Transport
for NSW

PCU040925

**EXHIBITION OF STAGES 2B & 2C, 2D & 3B – NORTH PENRITH MIXED USE DEVELOPMENT
(SSD 5346, SSD 5347, SSD 5349)
SECTION 75W MODIFICATION APPLICATION OF CONCEPT PLAN MP 10_0075**

NORTH PENRITH
STAGE 3B
 ROAD LAYOUT

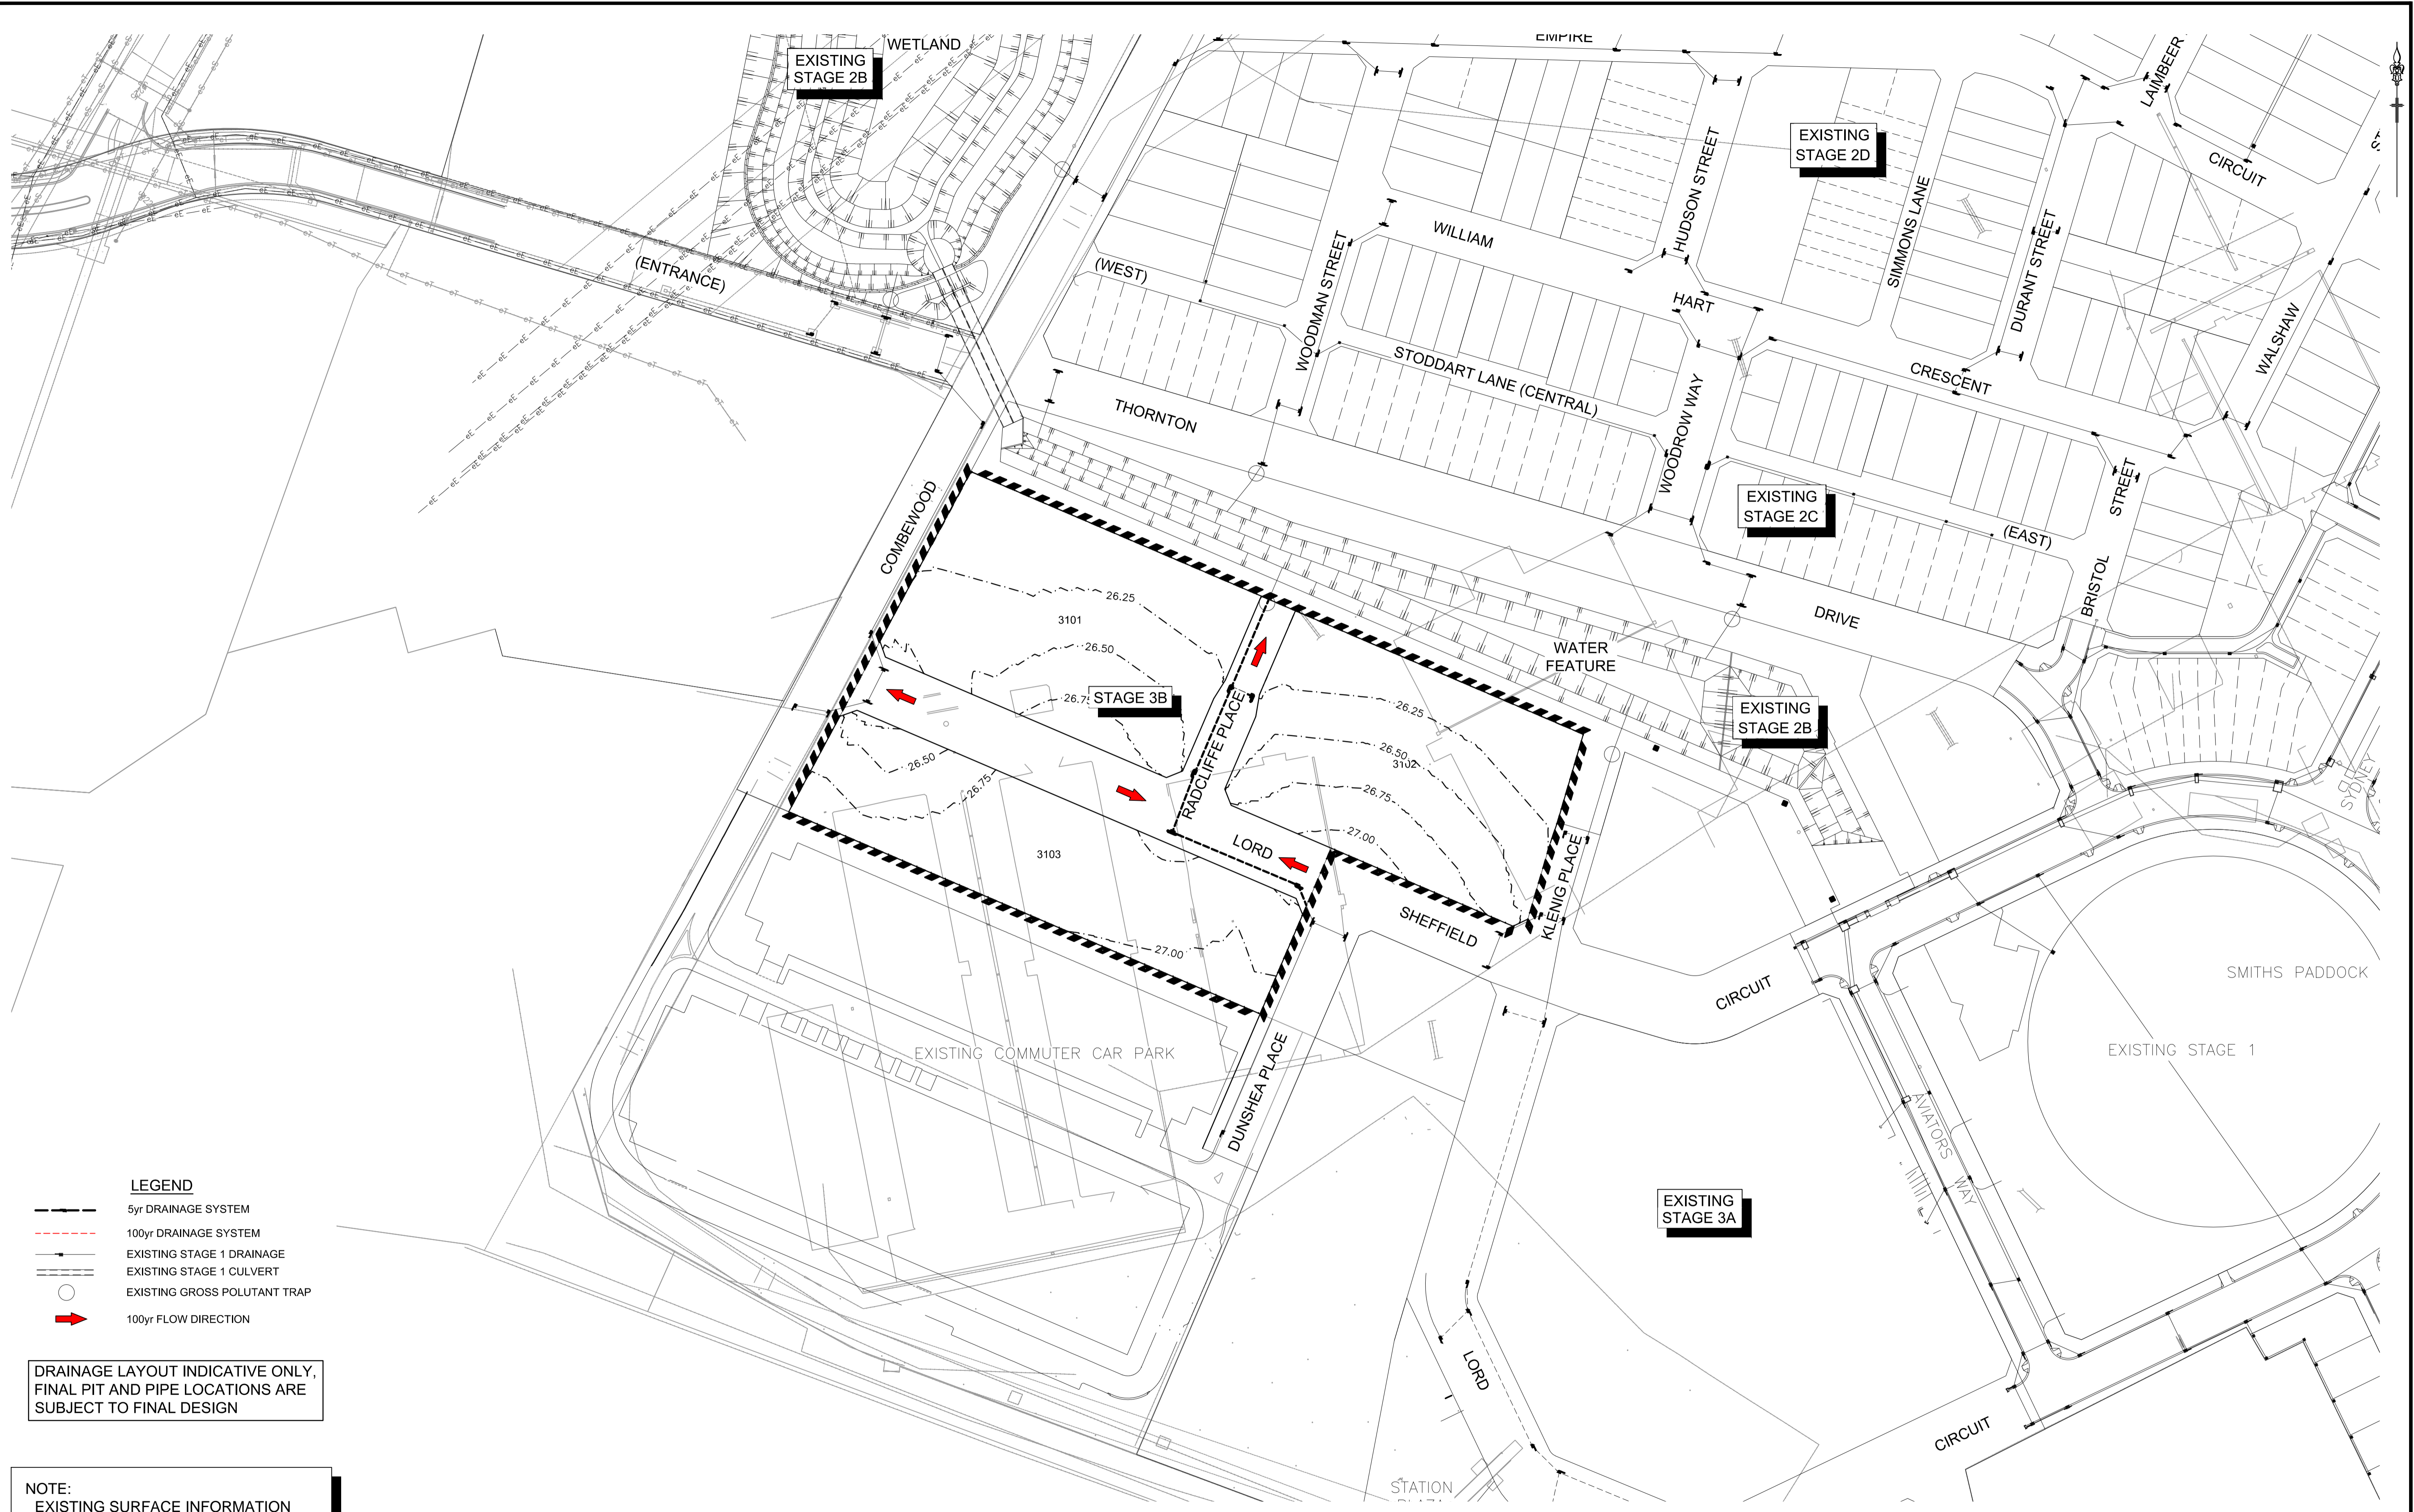
Further, with a view to providing maximum flexibility for future bus operations in an area that is close to a major railway station and regional city, the proposed roads and intersections as indicated in *Appendix A – 'Revised Concept Plans'* of the Modification Application report by JBA Pty Ltd dated November 2012, should be designed to accommodate overall bus manoeuvrability and swept paths of buses up to 14.5 metres in length such that there is no centerline crossing.

In particular, the proposed width of some of these roads (2.3 – 2.5 metres) and intersection layouts would permanently inhibit buses or larger service vehicles. It is important consideration be given to providing roads and intersections that can support bus manoeuvrability in accordance with the relevant standards. A diagram has been provided in Attachment A that indicates which roads should be considered.
